Observations By:	KC Waste Strategy(Refuse & Recycling)
Application No.	2022/91966
Proposed Development:	Outline application for erection of residential development
Location:	adj, Sunny Mede, Woodhead Road, Holmfirth, HD9 2PX
OS Map Reference	
Applicant/Agent:	A+DP Architecture & Design Ltd
Class:

Consultation Response from KC Waste Strategy(Refuse & Recycling)

Date Responded: 22/6/22

title Site Plan as Proposed  
number 22010D-04-P01  
scale 1:100/1:200/1:500/1:1250  
size A1

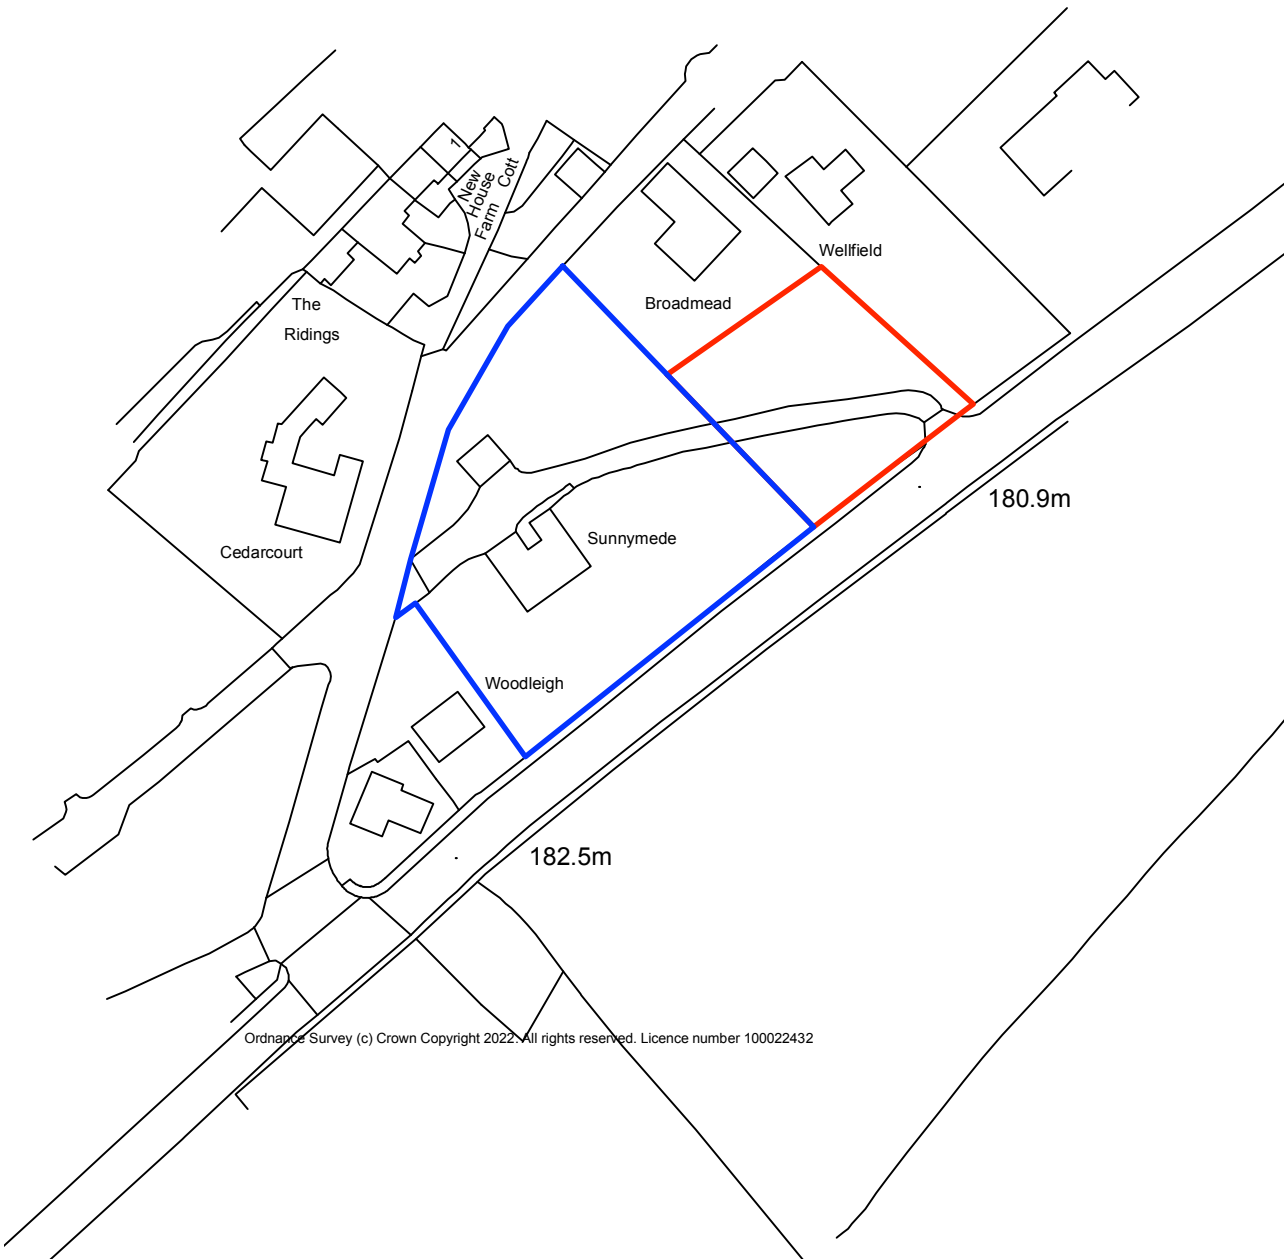
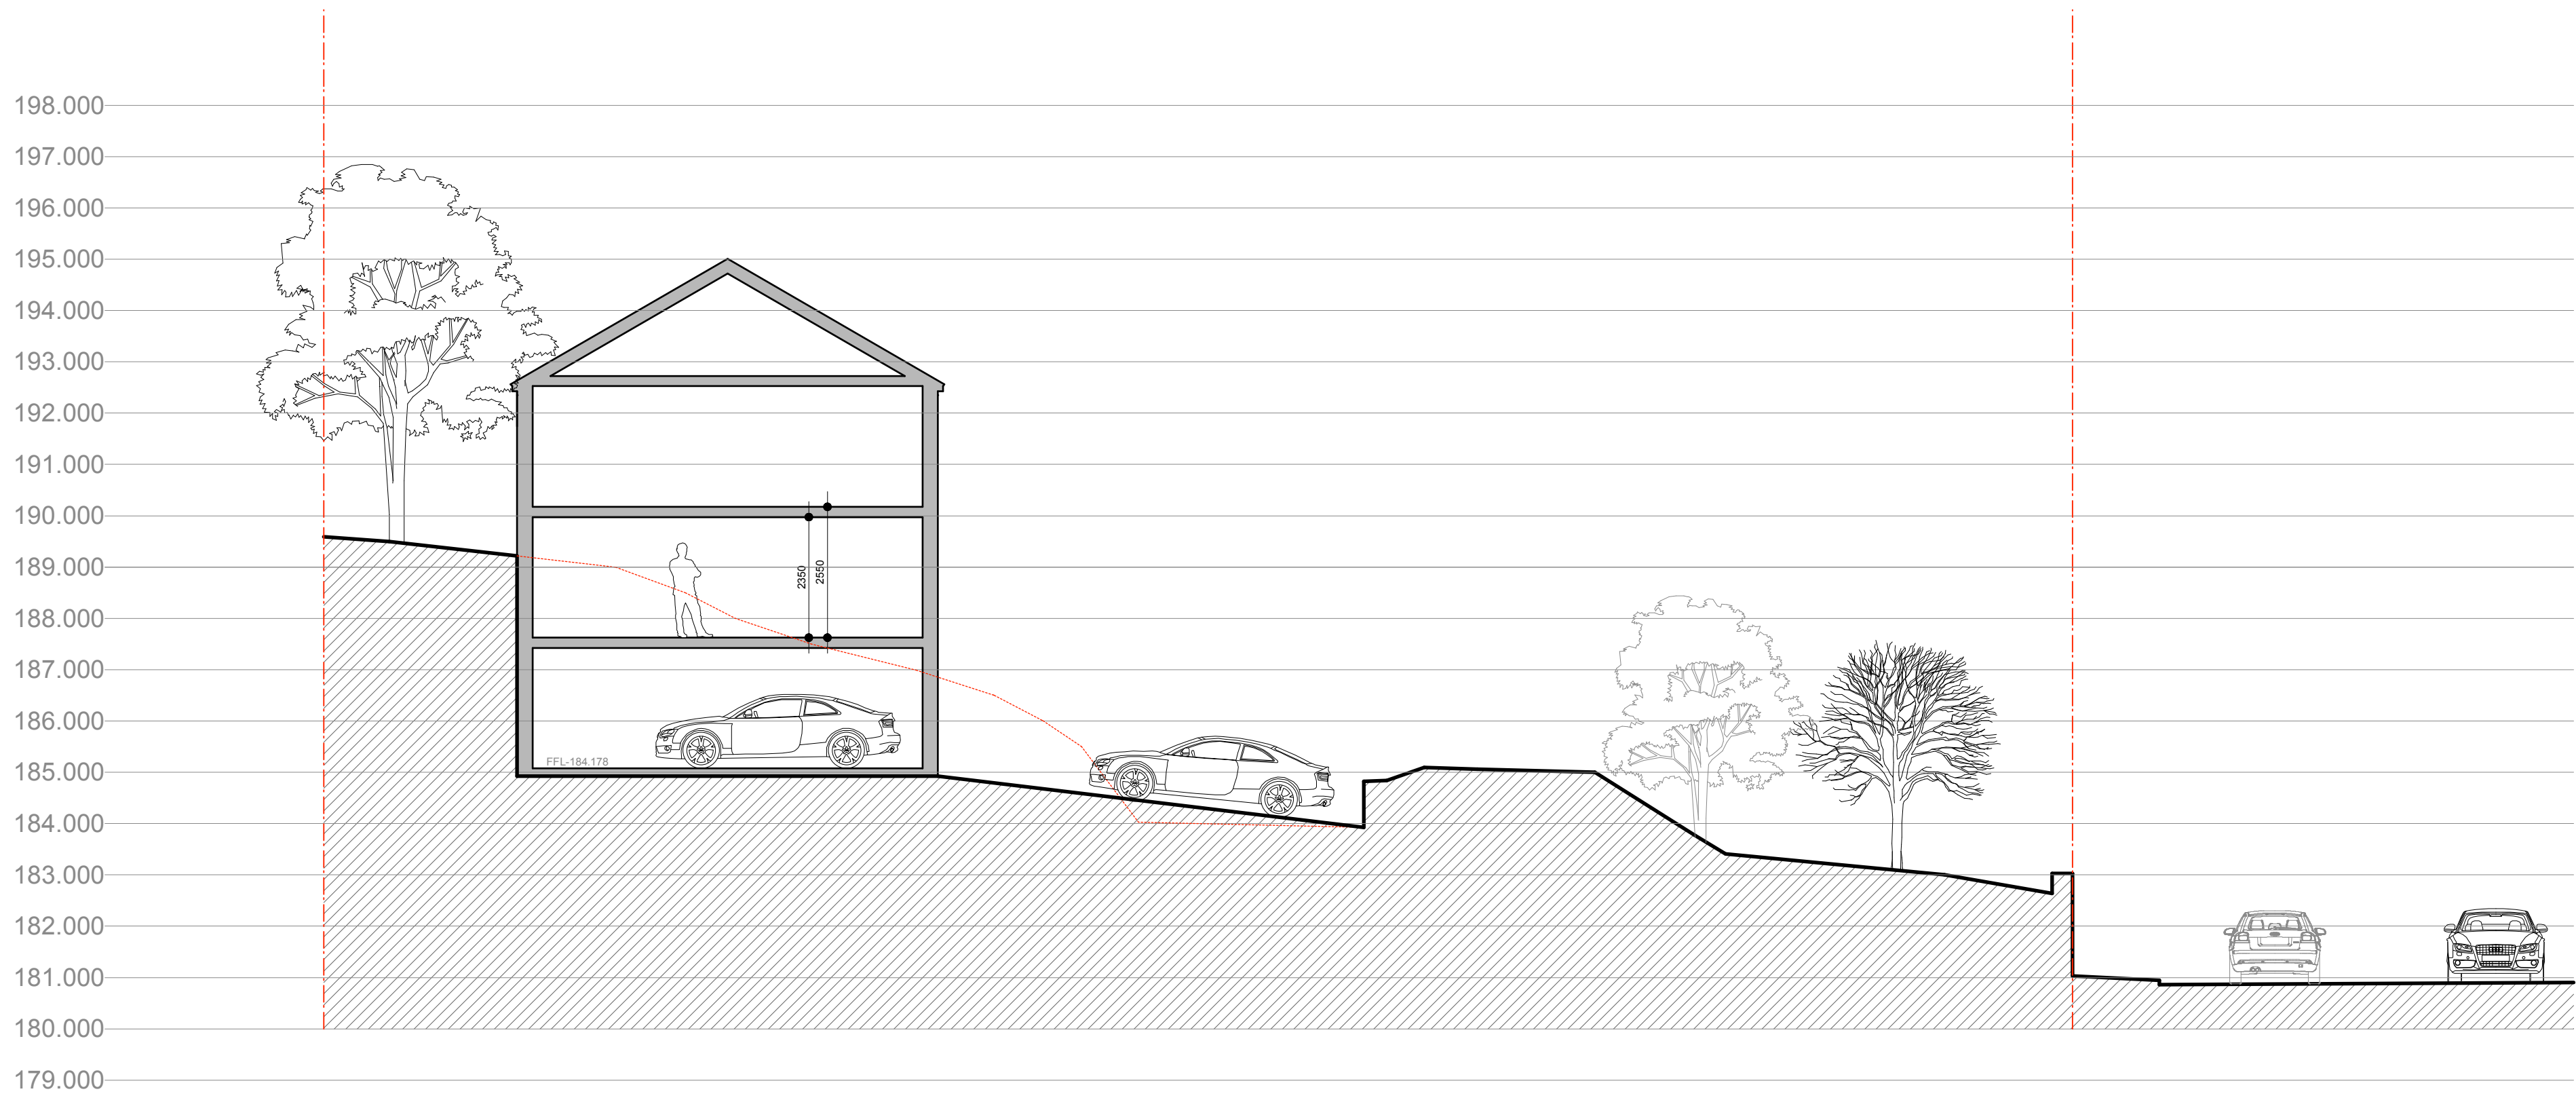
- The proposed site layout plan ref 22010D-04-P01 dated 28/4/22 shows a bin storage area next to the garage entrance for two bins. In view of the Kirklees Council waste strategy and forth coming changes to waste collection services it would be appropriate to have storage areas that can accommodate 3 x 240 ltrs bins. (1x240ltr Residual, 1x240ltr Recycling and as the property has a garden, the space to accommodate a third bin for garden waste.

- The Authority prefers storage of bins at the rear of properties However, the property is screened from Woodhead Road and the topography of the site means that there are steps to access the rear garden. On this basis the proposed location for the bin store shown on the plan is acceptable. The wheeliebin storage area must be of suitable dimensions to accommodate the bins and constructed in compliance with the details specified in the design guide. The route between the bin stores and Woodhead Road should not require residents to pull bins on gradients of more than 1:12.

- The site lay out plan shows access to the property by a private road / driveway. RCV's will not routinely enter private roads.
- On collection day the residents would need to transfer wheeliebins to a Bin Collection Point (BCP) close to the adopted highway and not left on the footway. The BCP should be shown on the site plan.

- The BCP for wheeliebins located close to adopted highway should be of appropriate dimensions and constructed to the specification detailed in the Kirklees Waste Management Design Guide 2020. The splay area of the existing drive would appear to be appropriate and avoids collection staff entering through the drive gates.
